Application no: **3/2021/0446**

Address: **Charnley Cottage Preston Road Longridge PR3 3BD**

Proposal: **Proposed erection of a new single storey dwelling in the garden of Charnley Cottage in lieu of 2 dwellings approved under outline application 3/2018/0682.**

The Local Highway Authority have viewed the plans and highway related documents and have the following comments to make:

Proposed Site & Roof Plan

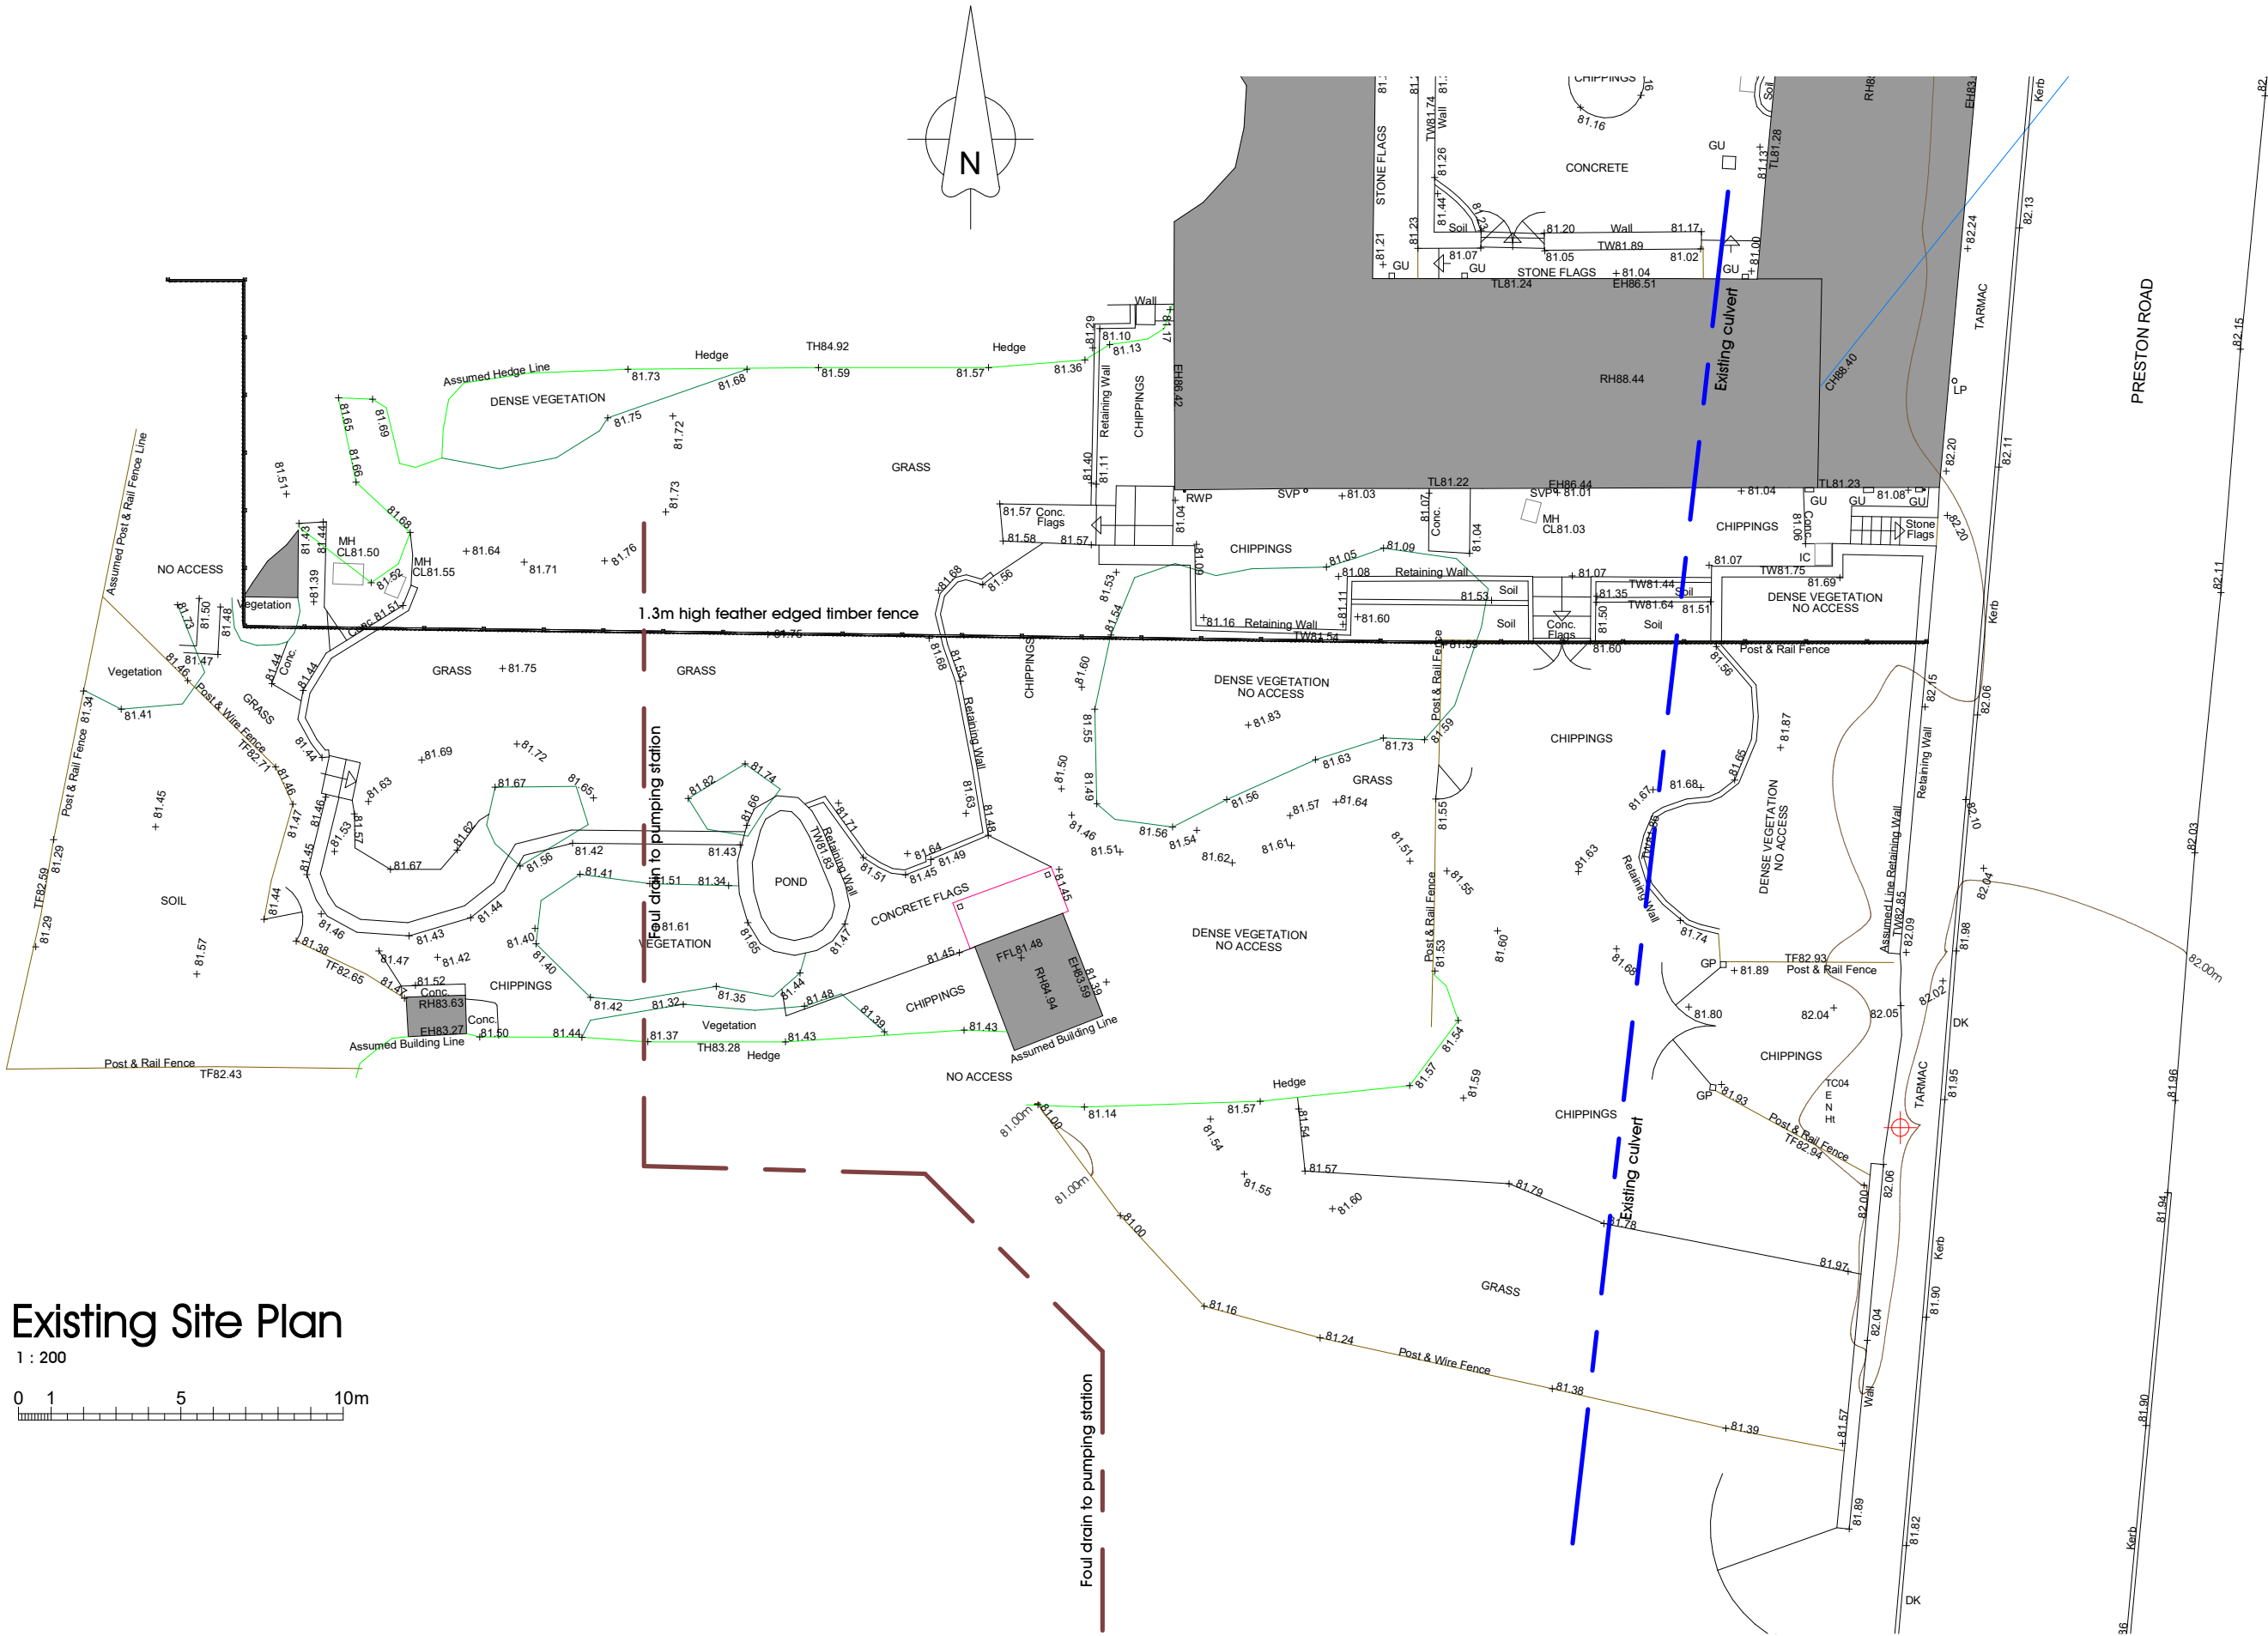
The LHA have reviewed PGB drawing number 030 titled "Proposed Site Plan" which shows the access complies with the LHAs standards. It is also worth noting the access was also previously approved under application reference 3/2018/0682 to serve two dwellings at the site. Therefore, the LHA have no objection to the use of the access.

1.No part of the development hereby permitted shall be occupied until such time as the access arrangements shown on PGB drawing number 030 have been implemented in full.

Proposed Plan

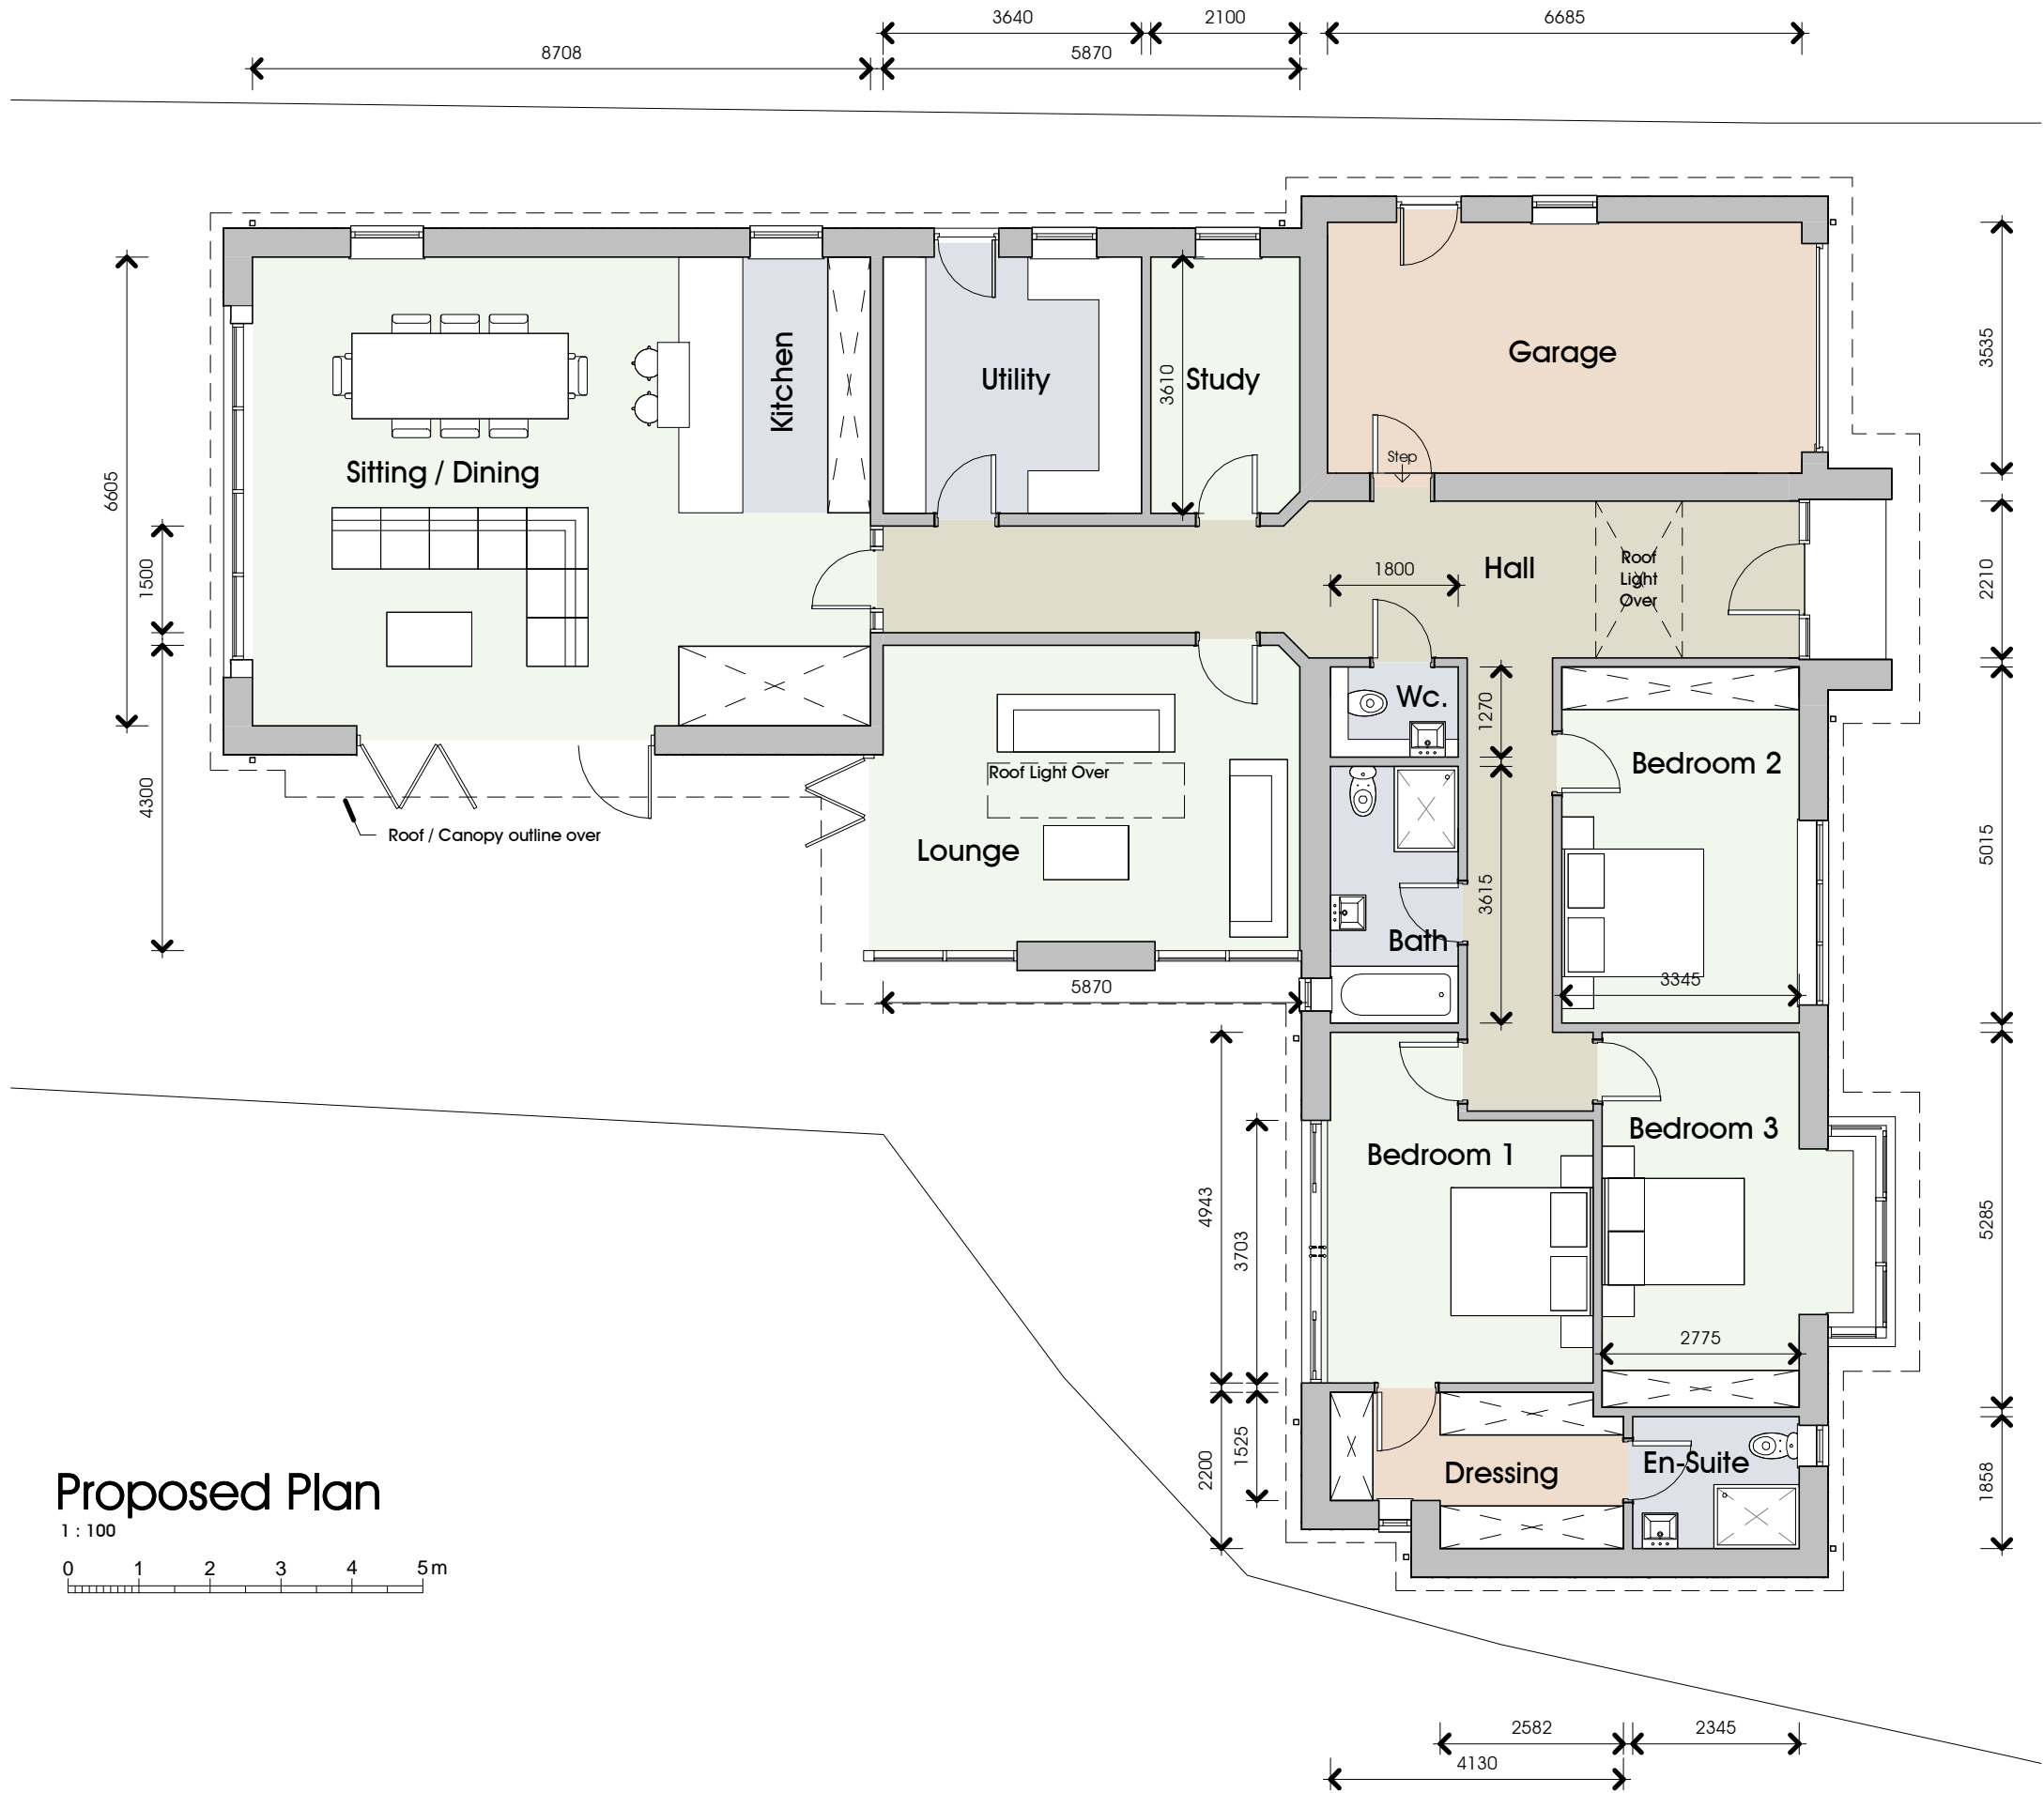
The Applicant is proposing to use an internal single garage as a parking space with the internal dimensions of the garage, which can be viewed on PGB drawing number 040 titled "Proposed Plan, complying with the LHAs guidance.

While the Applicant has failed to provide a parking plan showing where the other car parking space will be located on the site, the LHA are aware that the proposed driveway has adequate space to provide at least another car parking space. The driveway also has adequate space to provide a turning facility to enable vehicles exiting the site in a forward gear only. Therefore, the LHA have no objections to the proposal.
